Memorandum ABP-316178-23 – Request for Further Information

To: Stephen Kay, ADP
From: Alaine Clarke, Inspector
Re: Proposed development of Oweninny Windfarm Phase 3 consisting of 18 no. wind turbines within the townlands of Laghtanvack, Croaghaun (also known as Croaghaun West), Moneynieran, Corvoderry, Shanvolahan, Dooleg More, Shranakilly, Bellacorrick and Shanvodinnaun, Co. Mayo.
Date: 18th January 2024

Overview Sheet

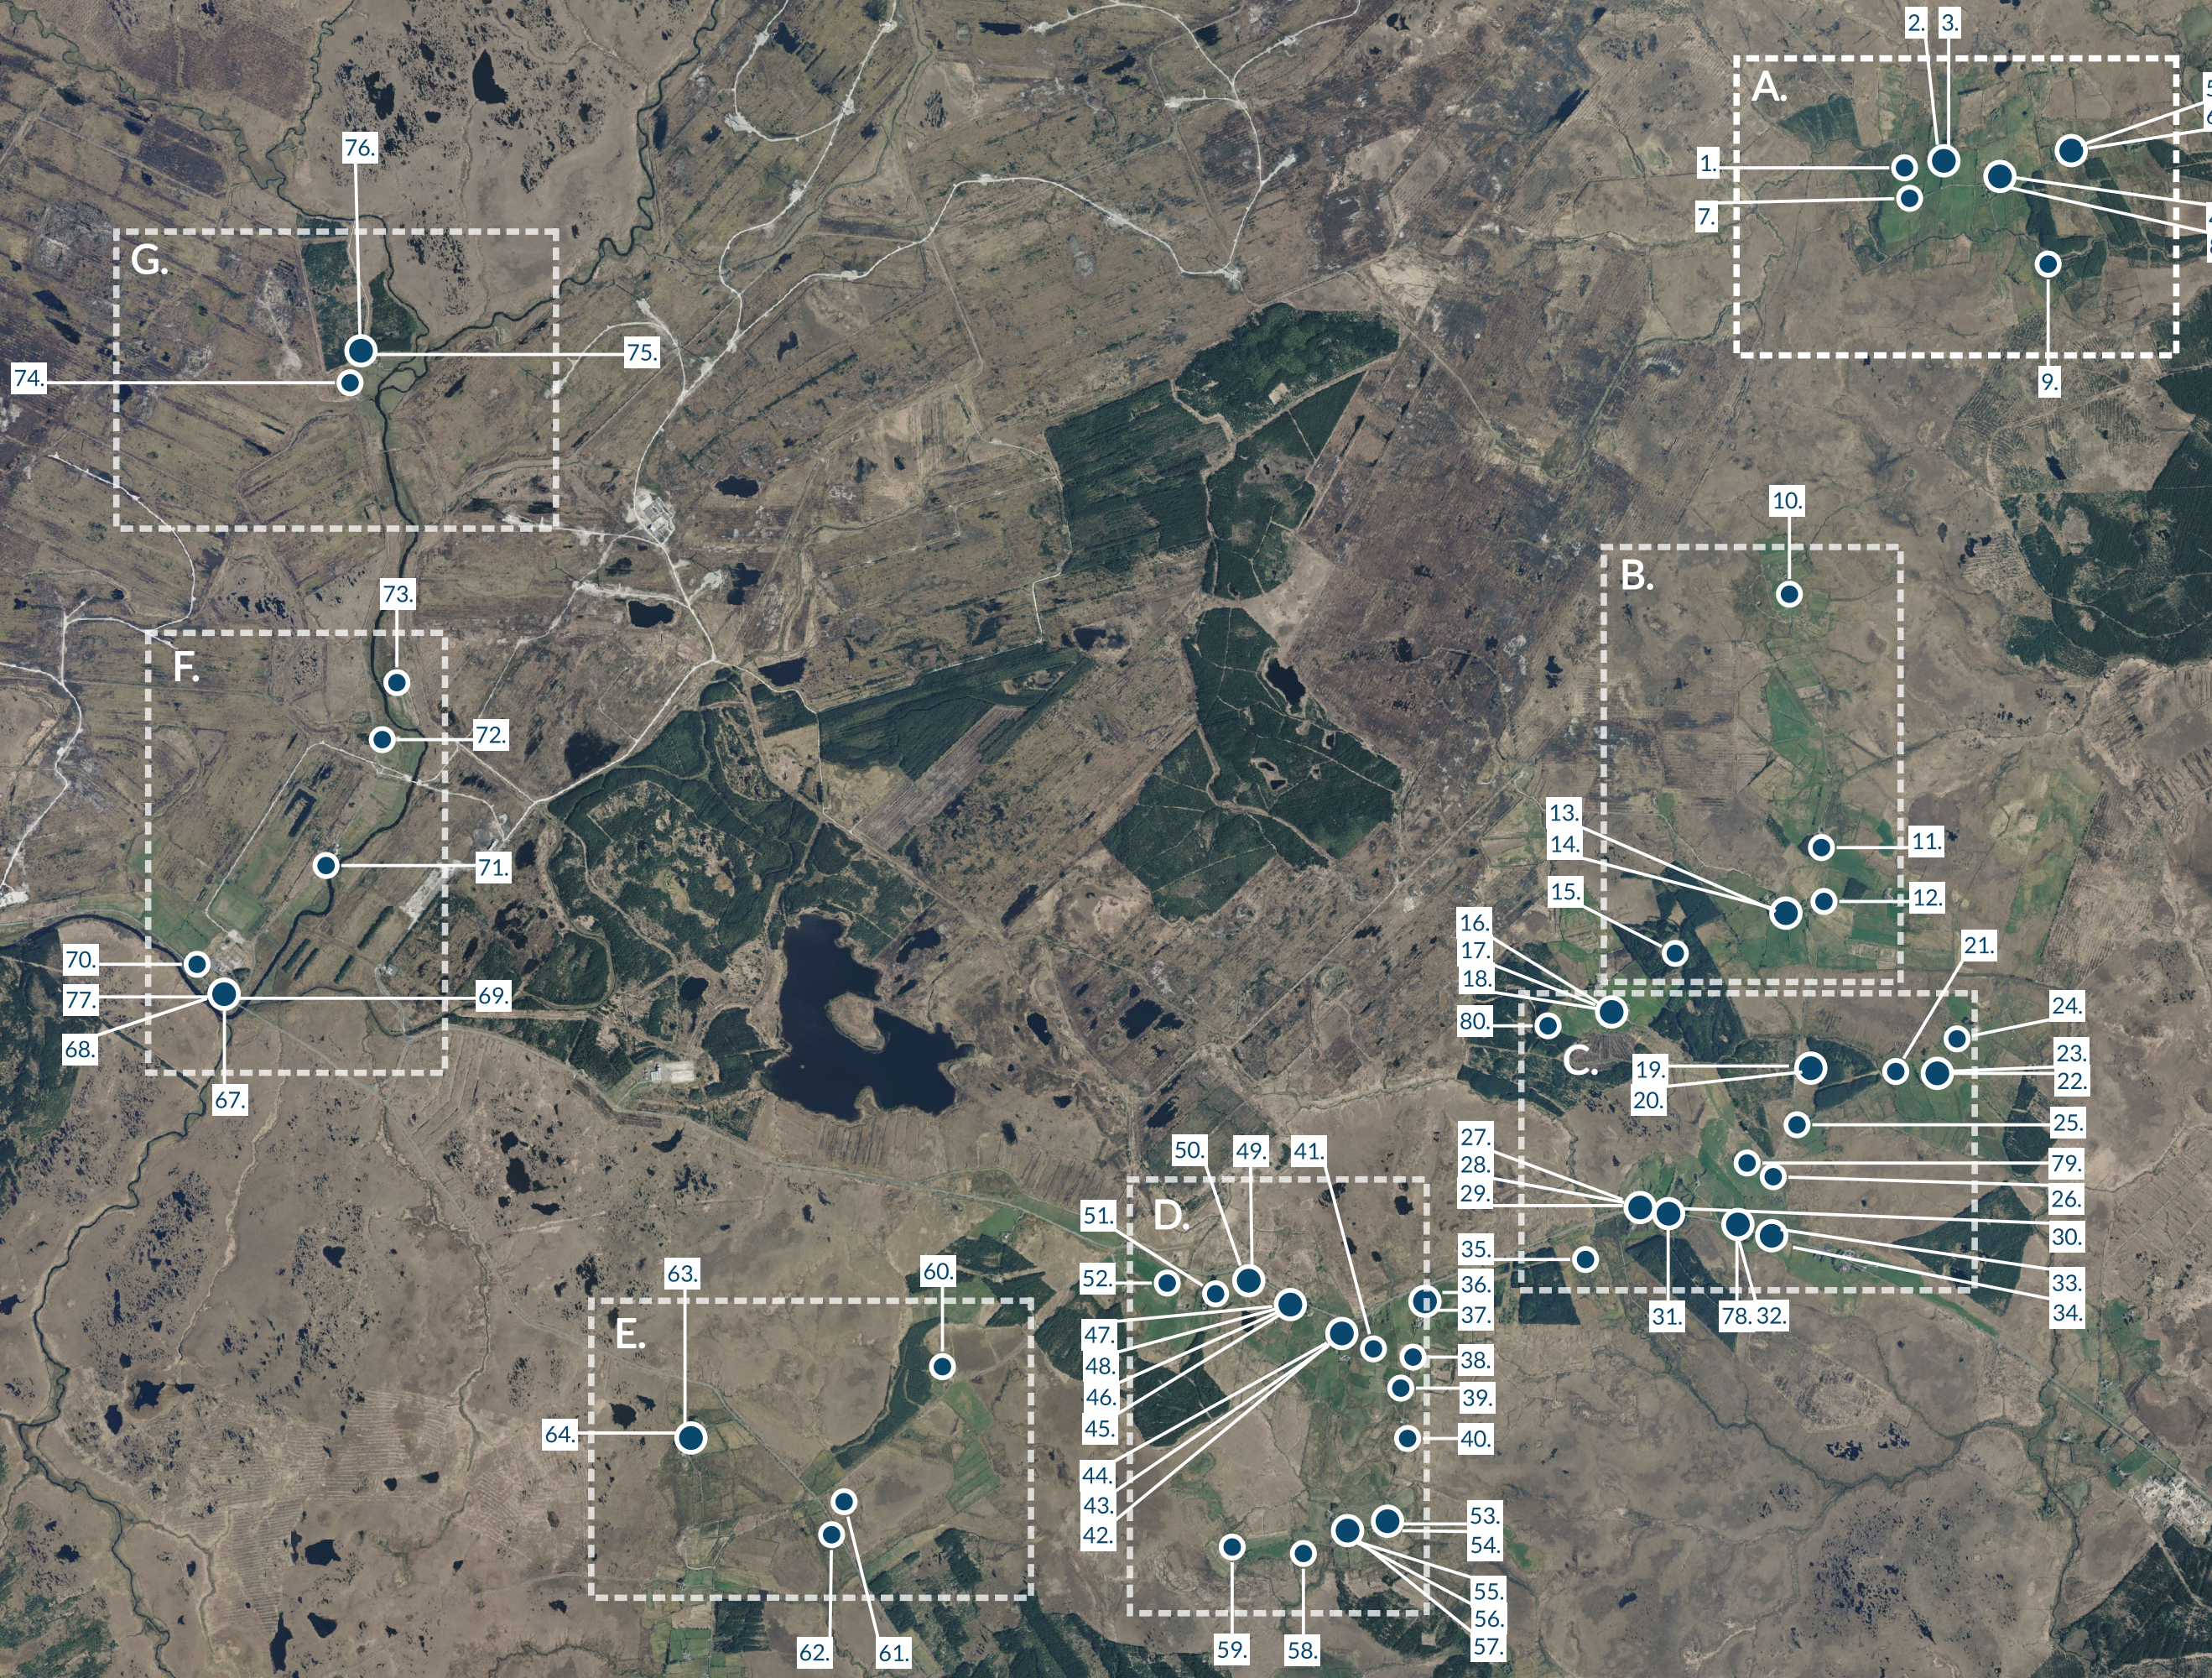
- (a) Submit a site layout plan which indicates the location of existing structures and development on site, including turbines and access roads. The site layout plan shall also indicate the turbines and access roads of adjoining windfarm

developments such as Phase 1 and Phase 2 Oweninny windfarm. Annotate and label the turbines (both on and off site). Indicate the extent of existing access track to be retained as part of the proposed development.
